CITY OF PORTLAND, MAINE
SITE PLAN REVIEW (ADDENDUM)
CONDITIONS OF APPROVAL

APPLICANT: Pine of Portland

SITE ADDRESS/LOCATION: #36 Liberty way lot 9

DATE: 3/16/00

CONCEPTUAL
LOT GRADING PLANS

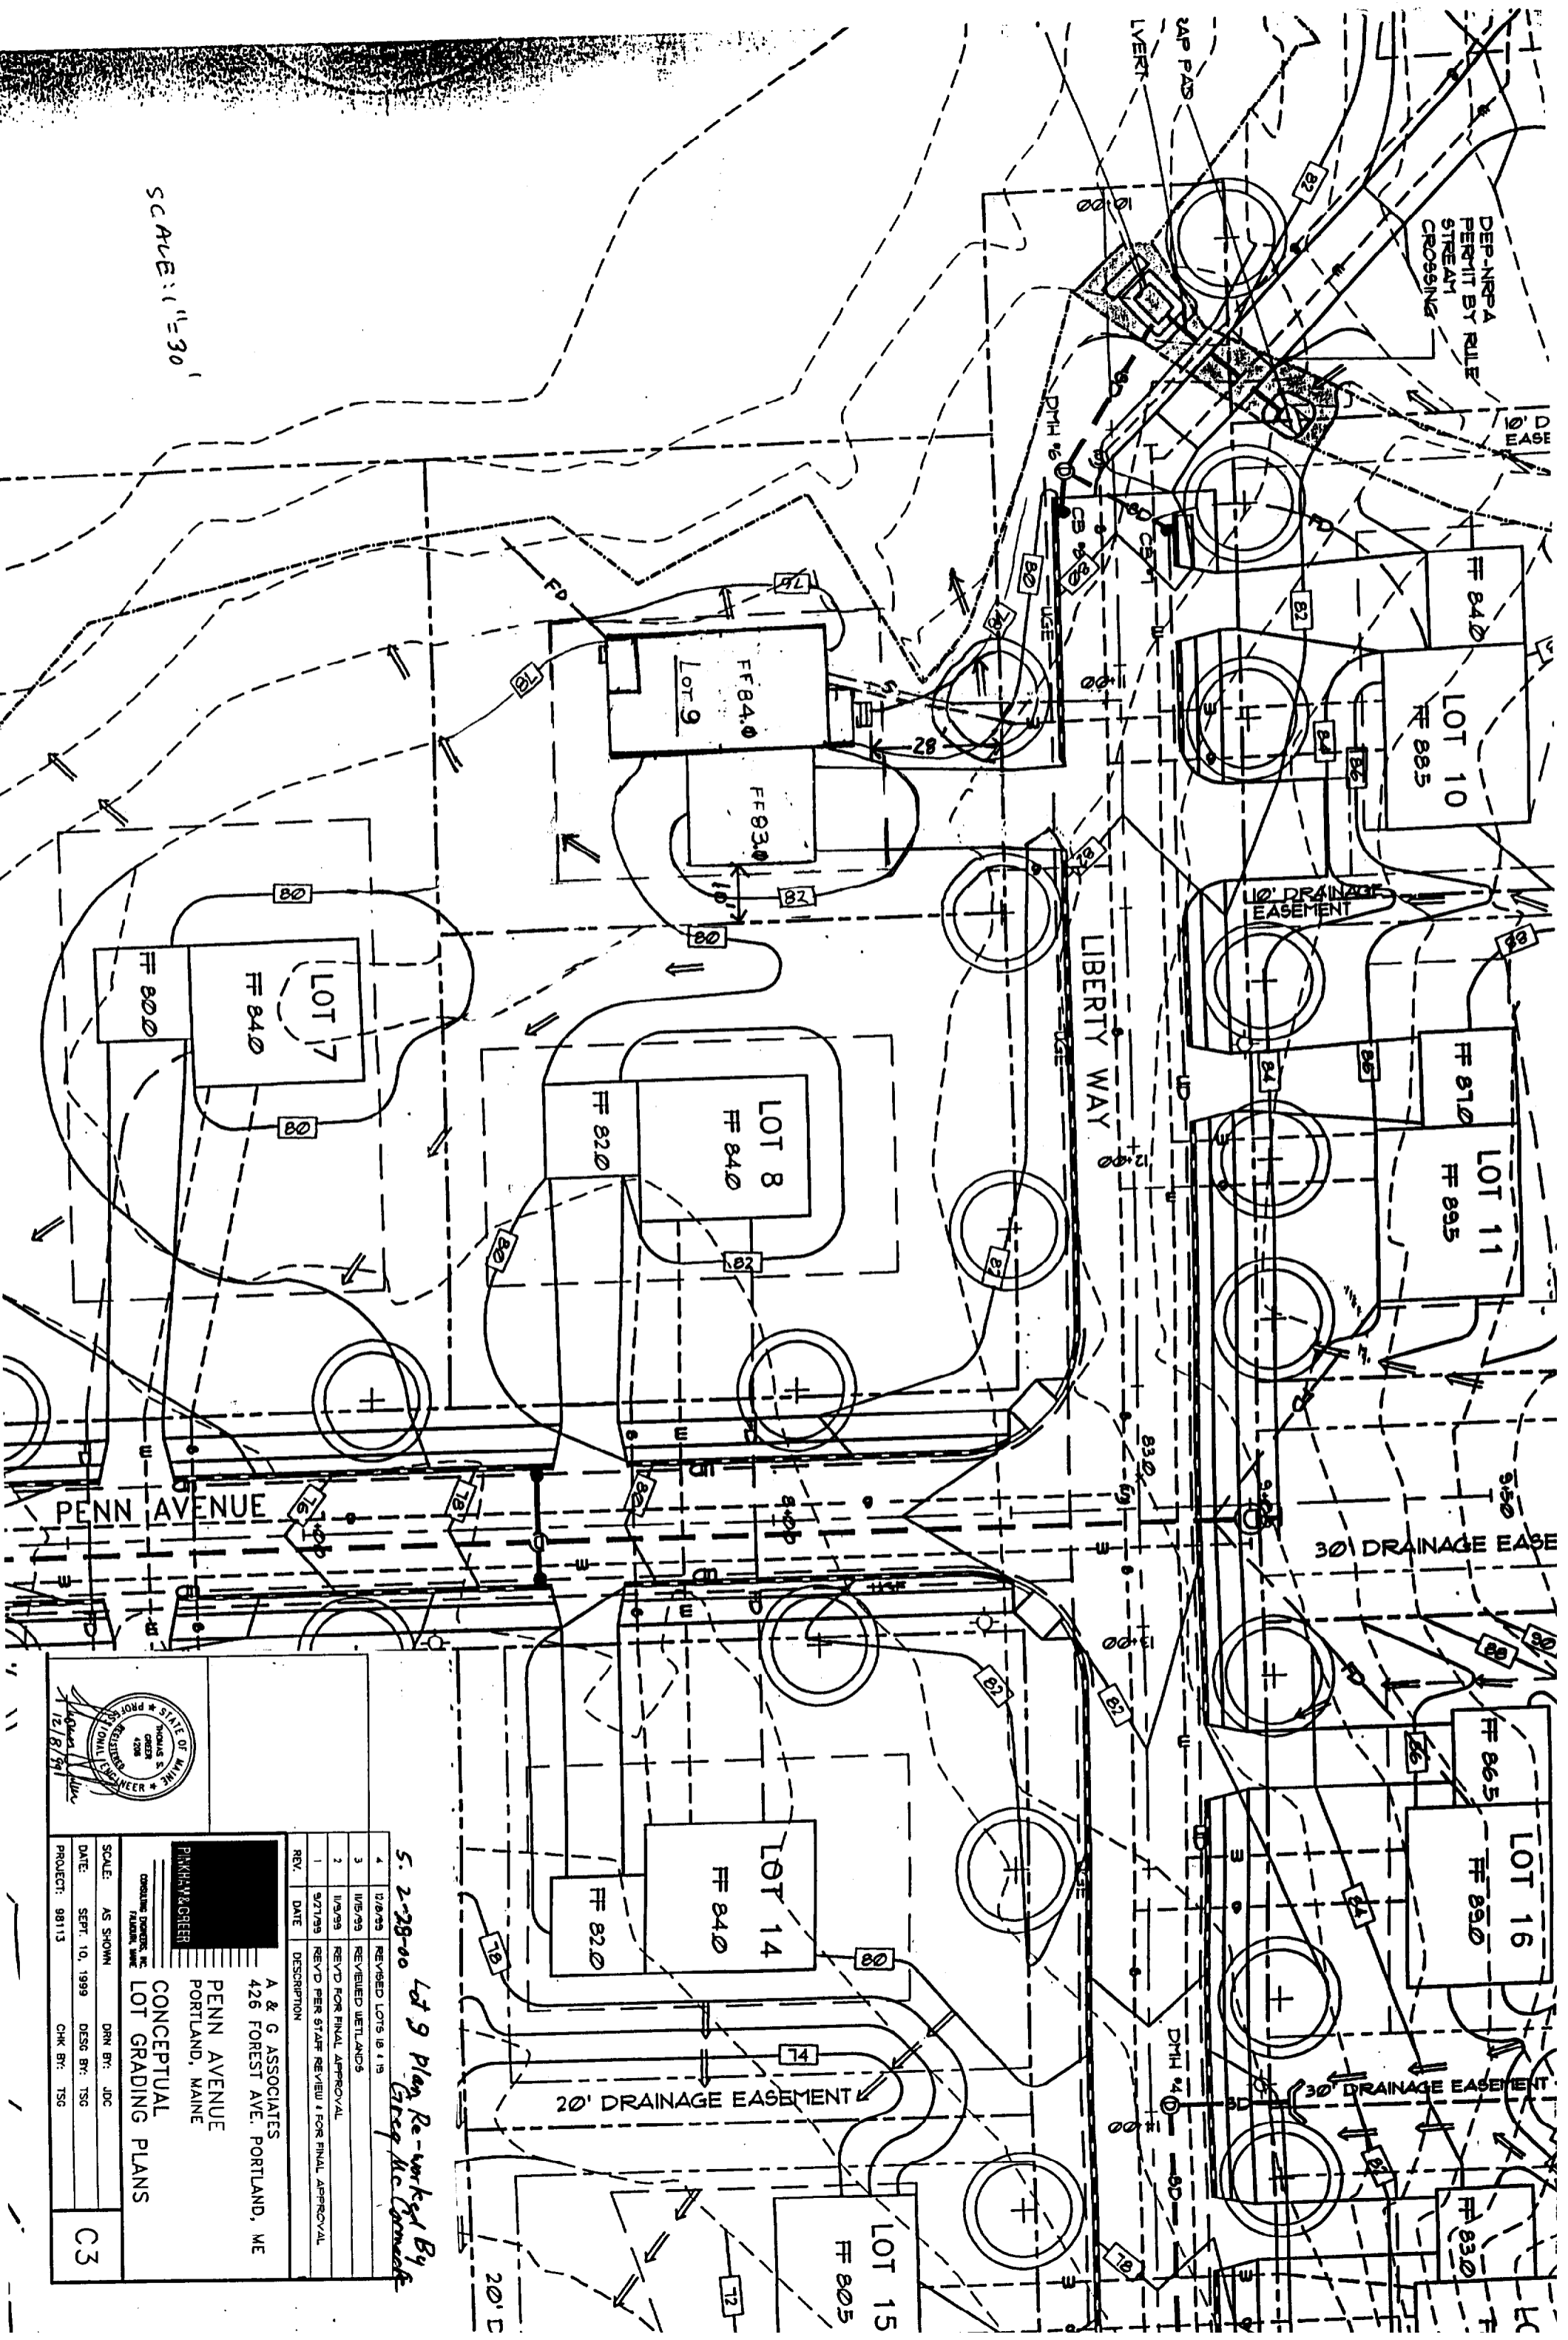
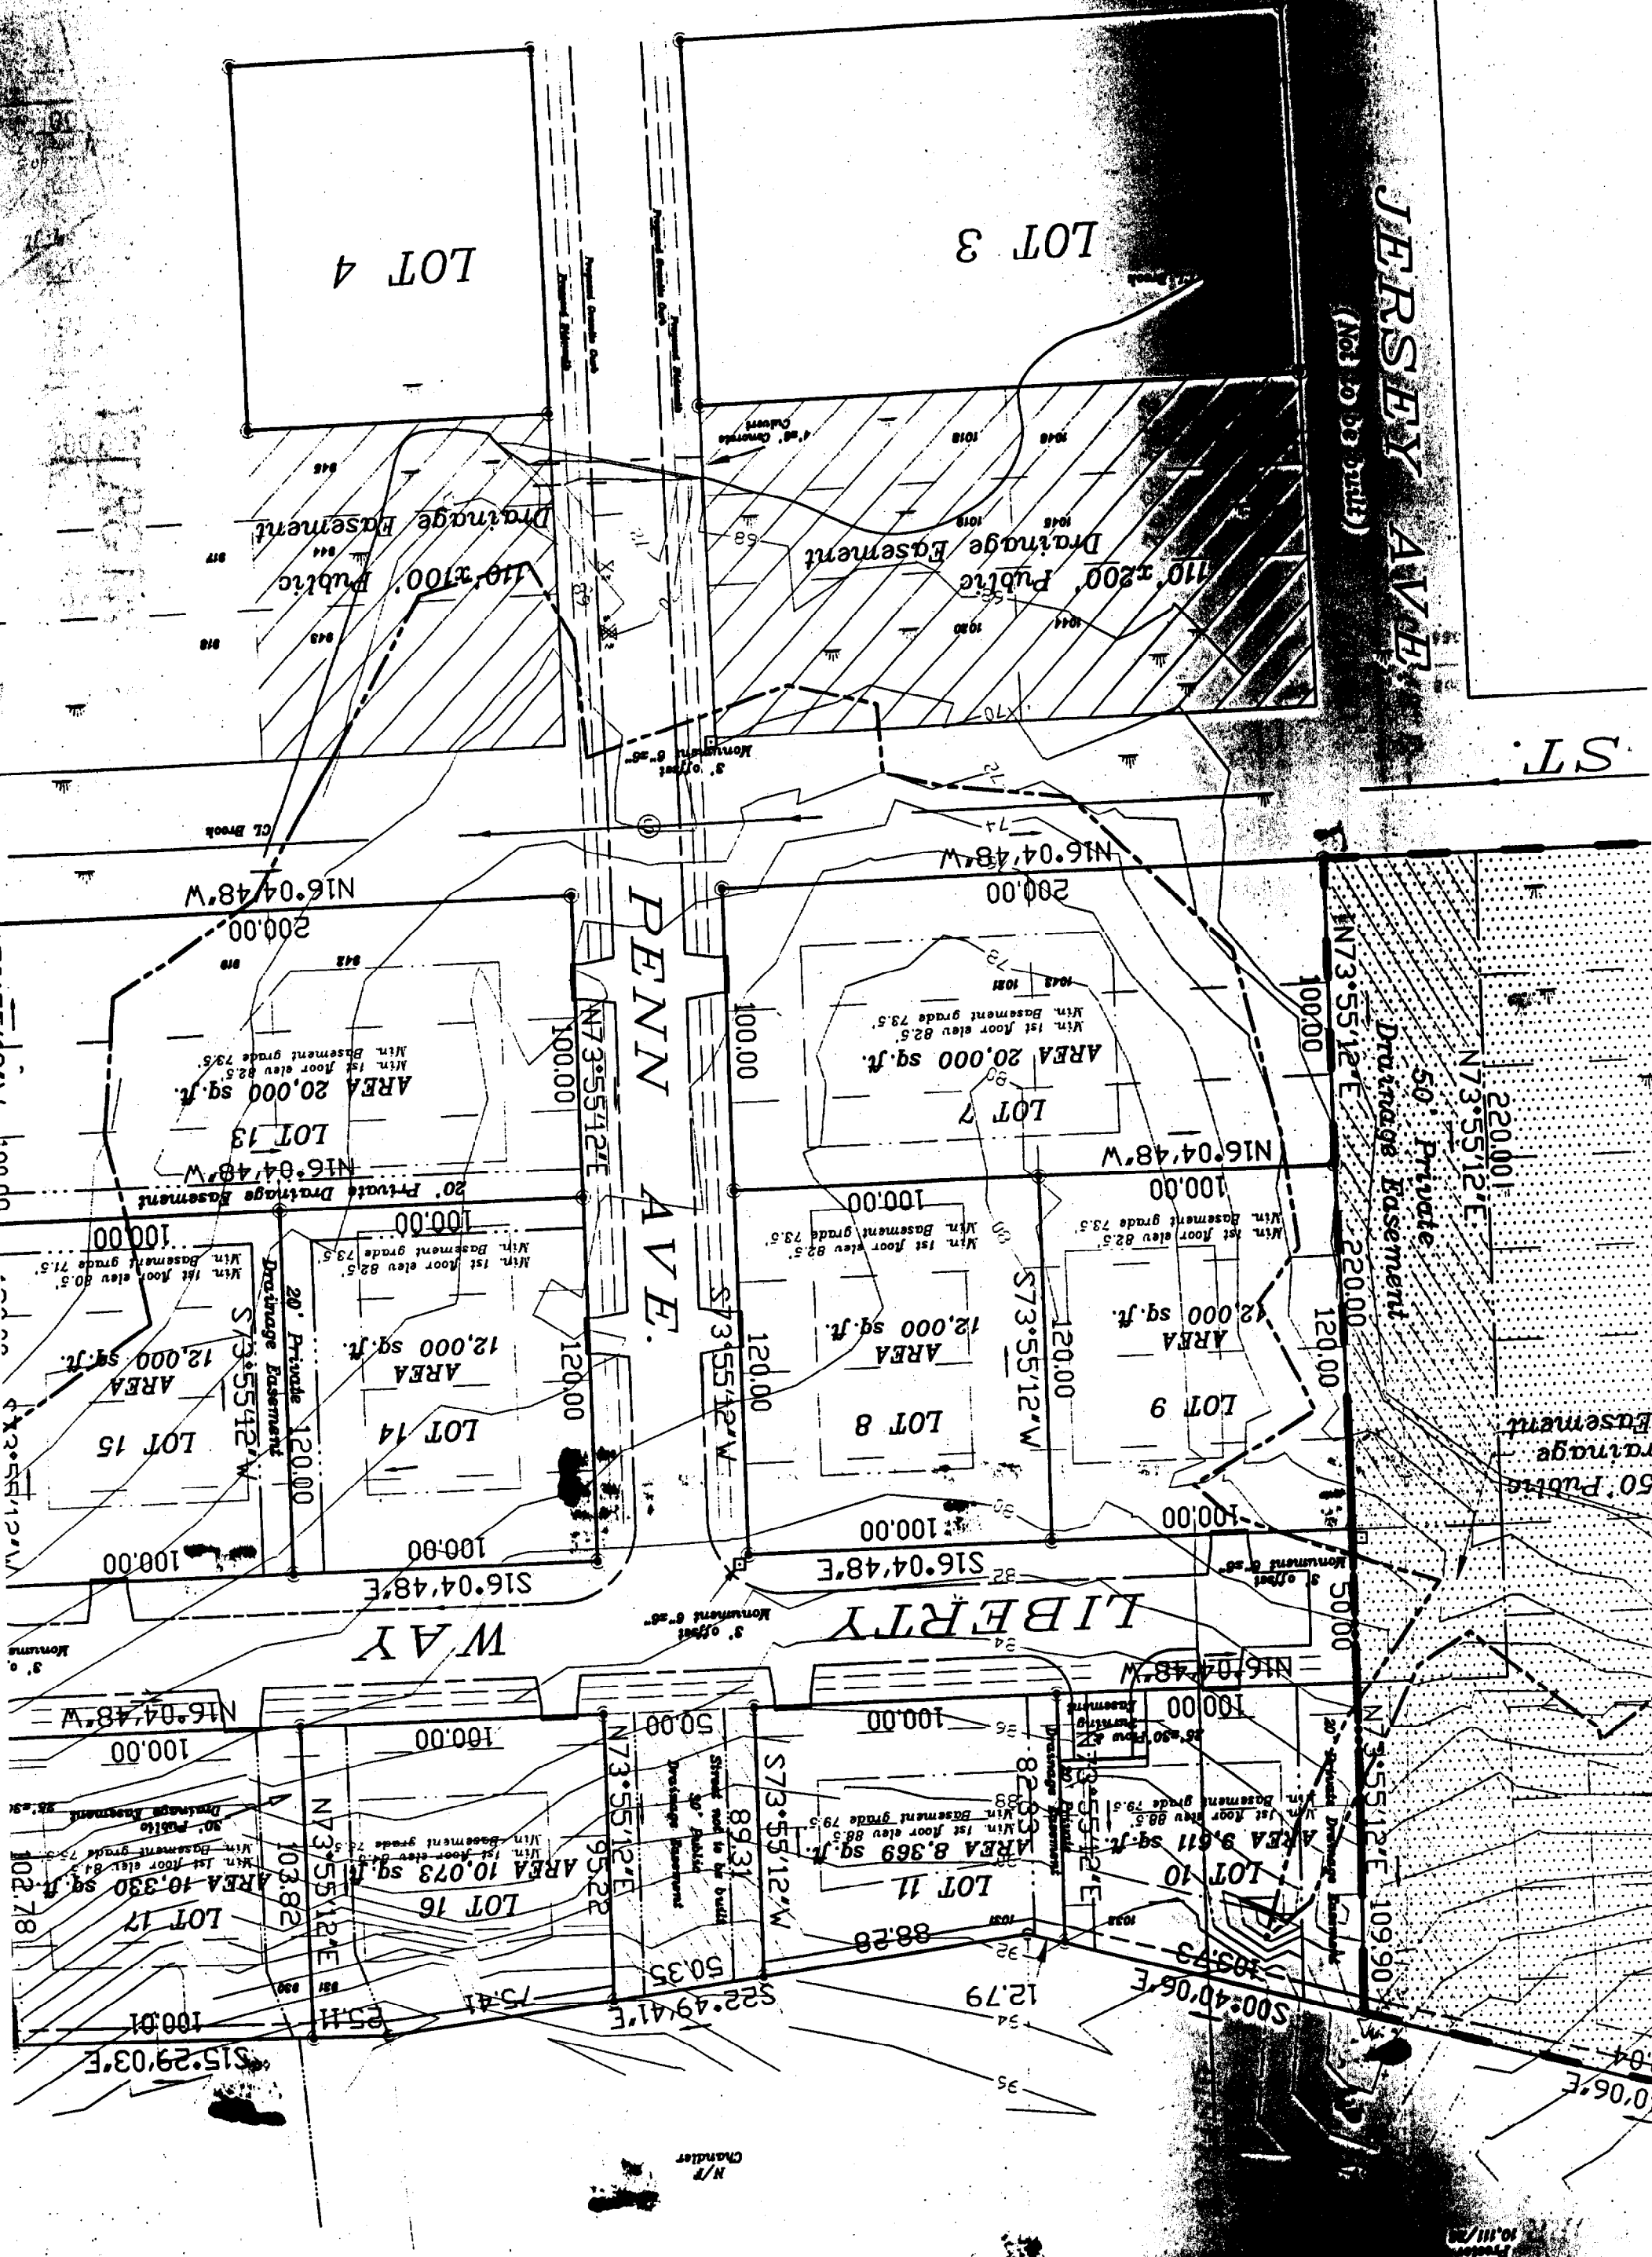
13. X Please Amend the plan for the following:

- Plan shall either be restamped by the Professional Engineer or the stamp removed
- Re direct drainage flow path between lots B & 9

to pass behind lot 7 and not across the front yard of lot 7

- Identify Any bulkhead location or daylight Basement entrance on plan.
- erosion control measures including silt fence shall be shown on plan
- An outlet invert shall be shown for the foundation drain. Will the FD be connected to a sump pump? This must be identified.
- The Applicant shall provide invert data for the sanitary sewer service. The sewer shall be insulated where there is less than 4' of cover.
- Water service shall have 5' cover minimum

• The driveway treatment shall be identified as asphalt, gravel or other
